TOWN AND COUNTRY PLANNING ACT 1990

Reference:	H06-0366-25	Date of Decision:	11th June 2025
Applicant:	Mrs K Rich Station House Station Road Gedney Spalding PE12 0DD		
Location:	Station House Station Road Gedney Spalding		
Description:	Proposed annexe for family member ancillary to main dwelling

**East Elevation**

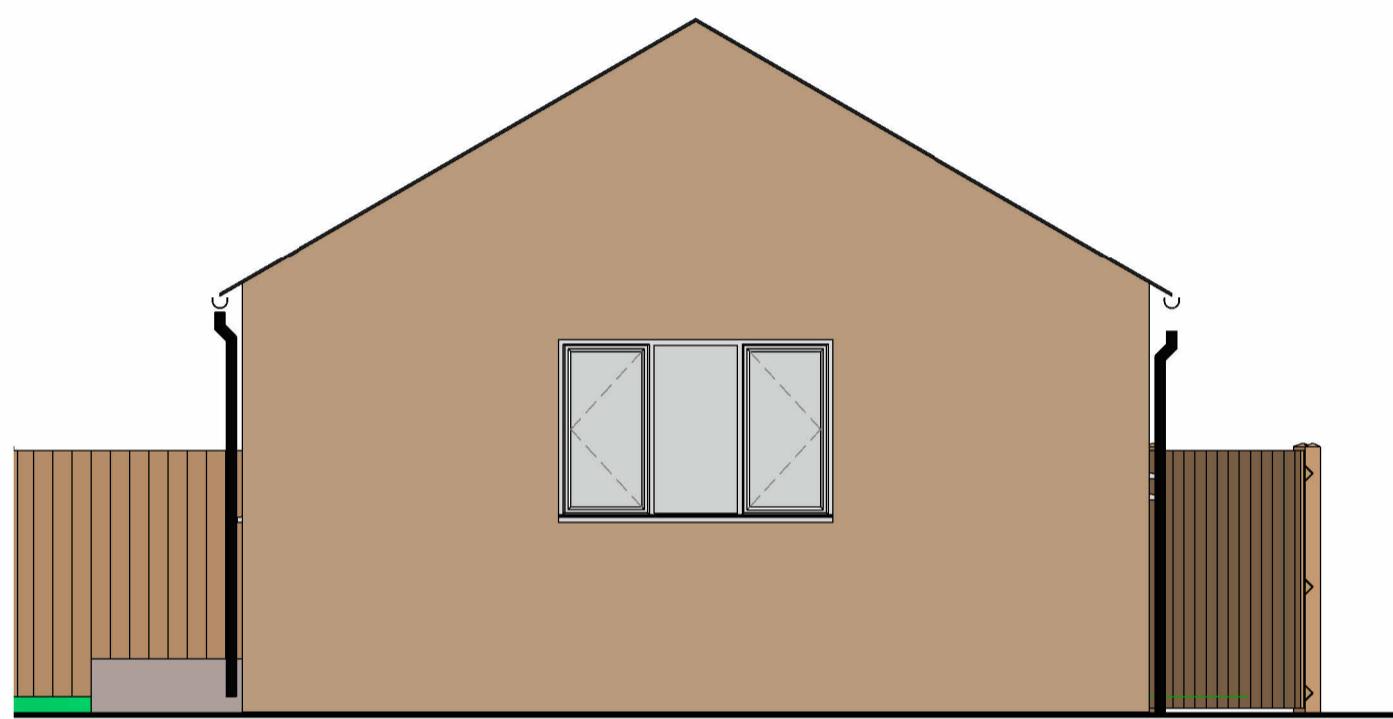
- 4 Notwithstanding the details submitted, before any part of the development hereby permitted is occupied, the following window(s) shall be installed with obscure glazing (to a minimum level of Pilkington - Privacy Level 3 or an equivalent product) and shall have no opening part being less than 1.7m above the floor level immediately below the centre of the opening part.

- East Elevation - Bathroom

Once installed, the window shall thereafter be retained as such.

Reason: To prevent overlooking in the interests of the amenity of nearby residents.
